LSC TRANSPORTATION CONSULTANTS, INC.
545 East Pikes Peak Avenue, Suite 210
Colorado Springs, CO 80903
(719) 633-2868
FAX (719) 633-5430
E-mail: lsc@lsctrans.com
Website: <http://www.lsctrans.com>

MEMORANDUM

SUBJECT: Falcon Marketplace Driveway Permit Application
Woodmen Road Access Review 2
EPC File: AP-17-548
Response to Comments Memorandum
LSC #164350

PRELIMINARY
SITE PLAN

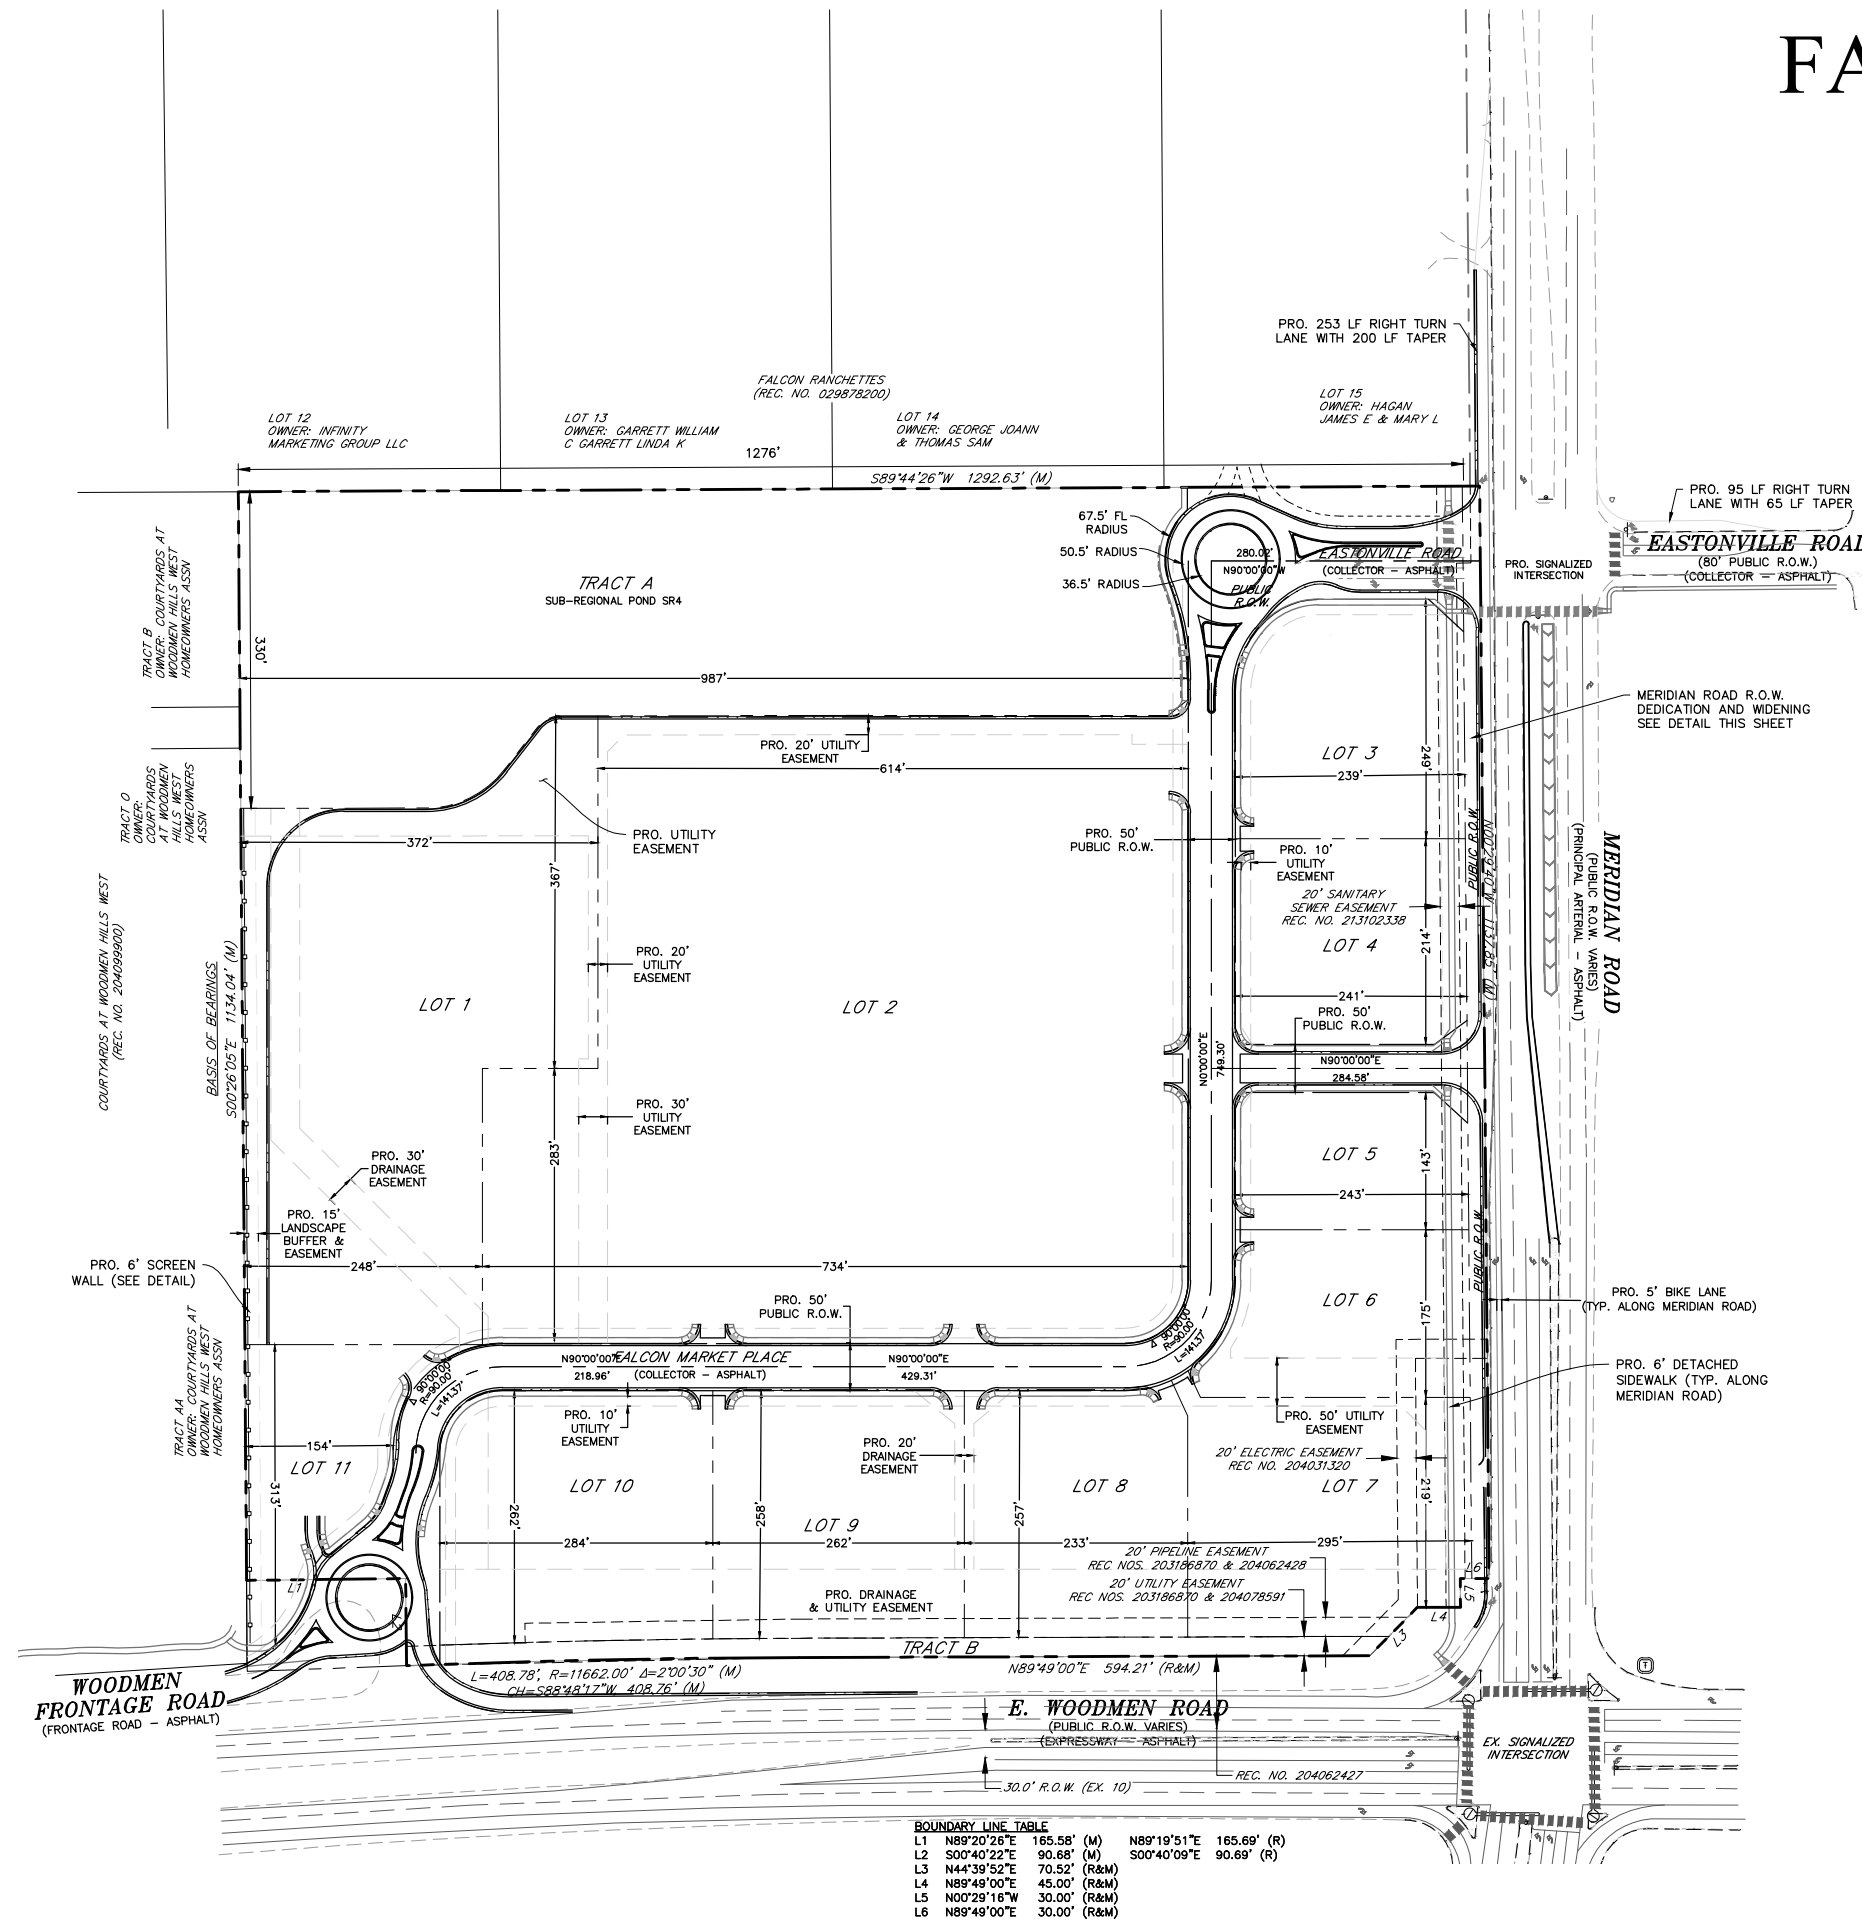
- a. The roundabout entry legs do not appear to be geometrically aligned to provide for the safest fastest path operations. The westbound movement appears to be designed as a free entry or bypass into the site, which will not function properly with the other legs. Traffic exiting Woodmen Road (the westbound movement) is likely to assume it has right-of-way to enter the site freely, which will conflict with the eastbound/northbound movement, and possibly the southbound movement depending on its exit leg.*

Unresolved; provide complete roundabout details meeting the specified criteria and matching modeling per comments below. The proposed deflections entering the roundabout are still of concern, and other issues remain, including appropriate overall sizing (inscribed circle) and alignments for the design vehicle and other vehicles that will utilize the roundabout.

- b. The access from Lot 11 is not designed as a proper roundabout leg. Resolved (pending further revision due to other comments regarding roundabout size)*
- c. Resolved*
- d. If the RI access with roundabout is approved, 60% to 90% roundabout technical reports and construction plans (for both roundabouts) will be required with the Preliminary Plan submittal to allow for adequate review time.*

LSC Response: The roundabout has been redesigned to address the comments. The resubmittal includes the complete set of roundabout details.
